Subject: RE: INVALID APPLICATION : STAGS COLLECTION CENTRE, TOWER ROAD, OFFWELL (24/0132/DOC)

The submitted details do not appear to cover the following condition requirements, please therefore request this additional information from the agent/applicant:

Title: PASSING BAY & BANK DETAILS Dwg No. P06
 Dwg Status: Planning Rev. P 1

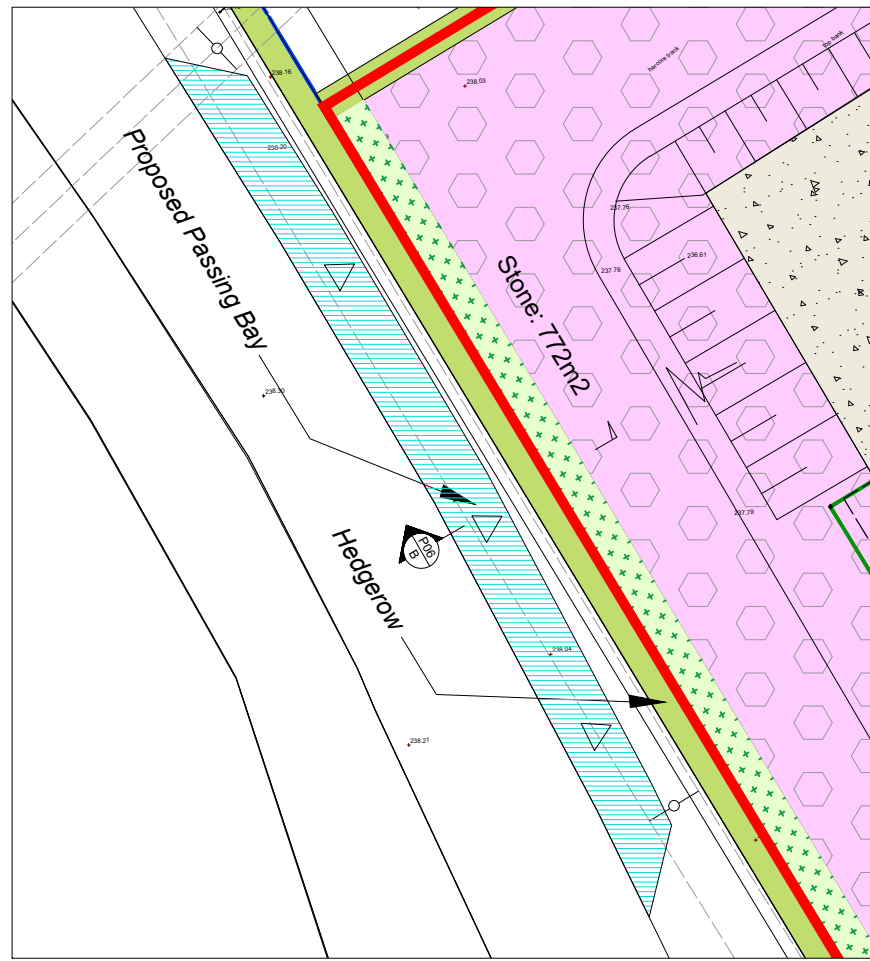
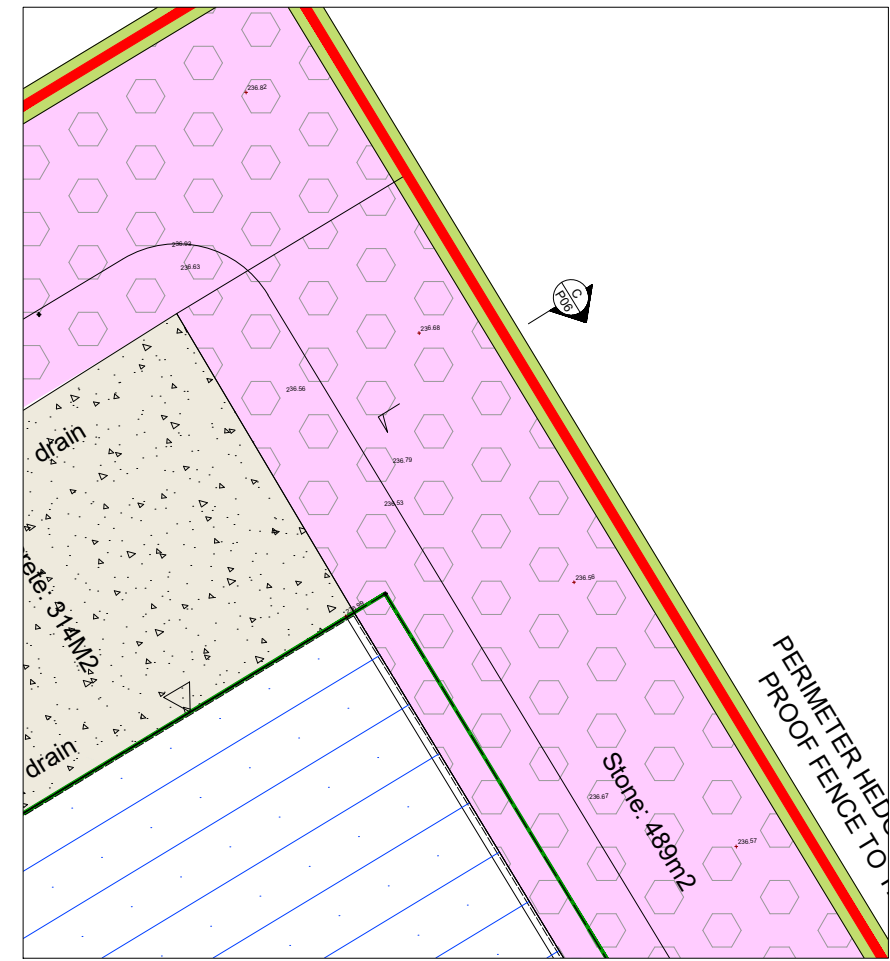
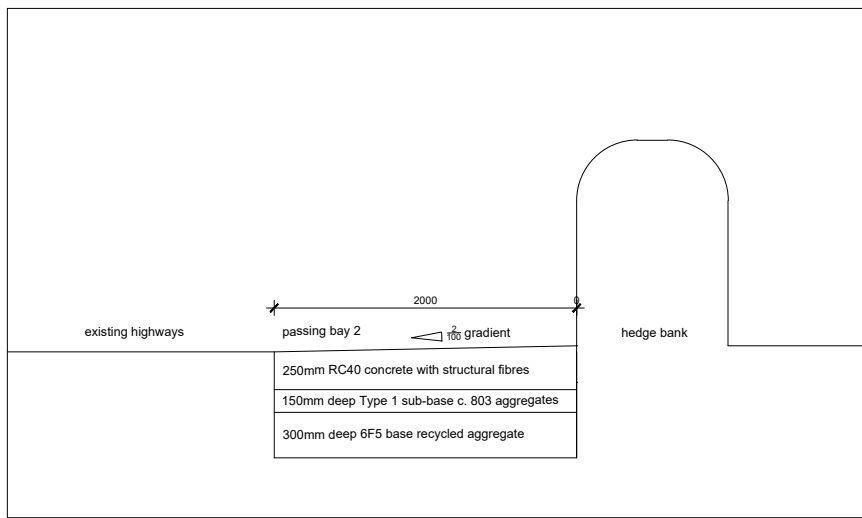
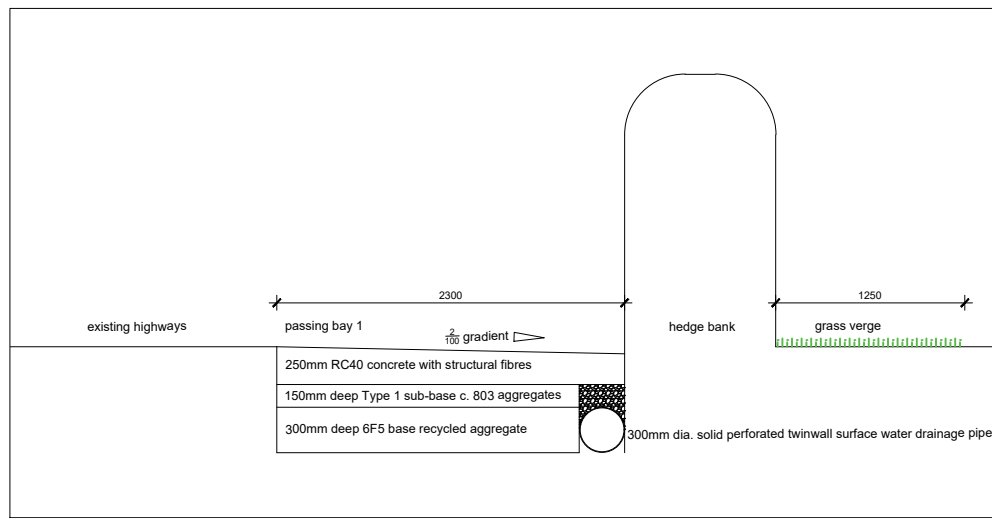
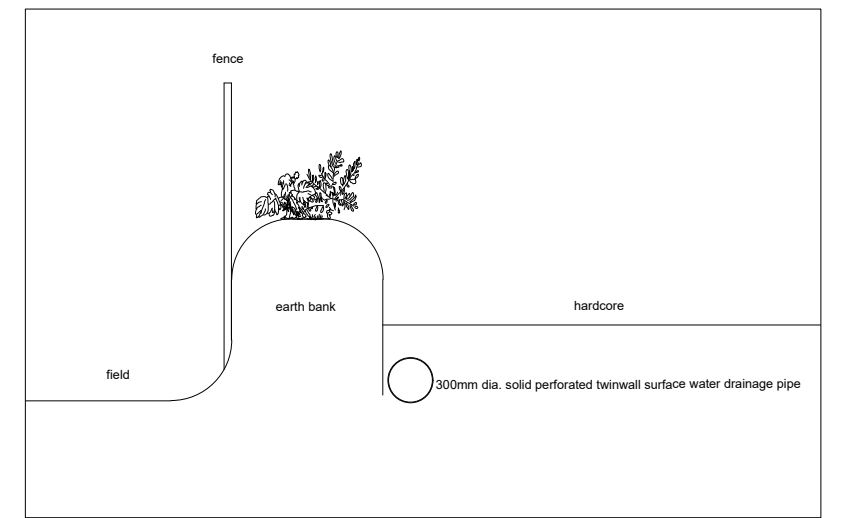
- *Condition 4 – Drainage details in relation to the northern passing bay*

There is no specific drainage proposed as the passing bay follows the existing site levels and there is no ditch/other drainage network at this point

**Title:** LANDSCAPING SCHEME  
**Dwg Status:** Planning  
**STAGS - PLANNING, DESIGN & ARCHITECTURAL SERVICES**  
 T: 01392 439046 - E-mail: planning@stags.co.uk - www.stags.co.uk

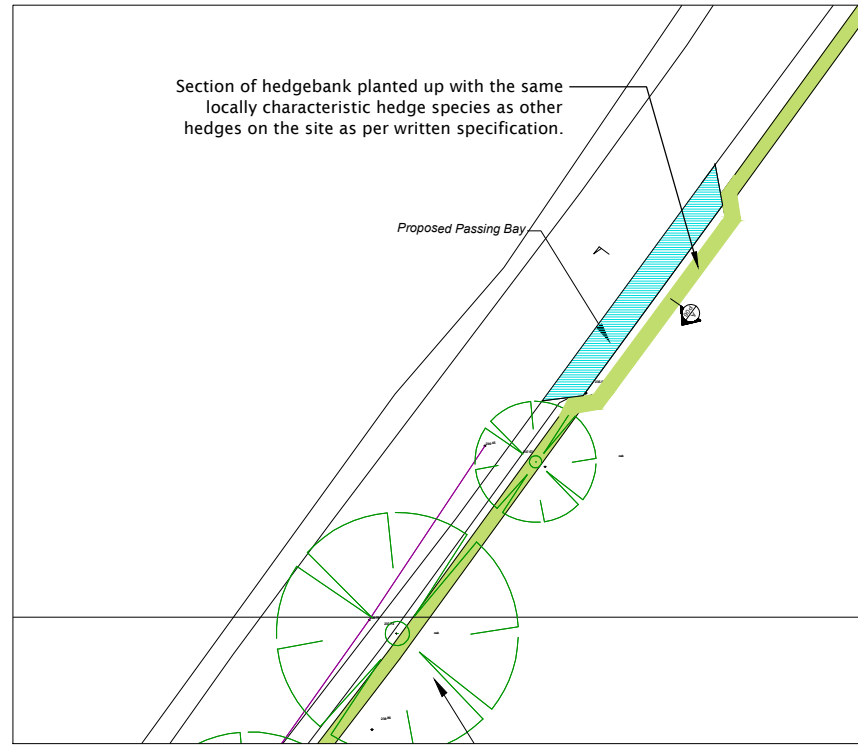
- *Confirmation of the dimensions of the signage installed on the gable ends of the building. **I can confirm the signs are 4.5M x 1.226M.***
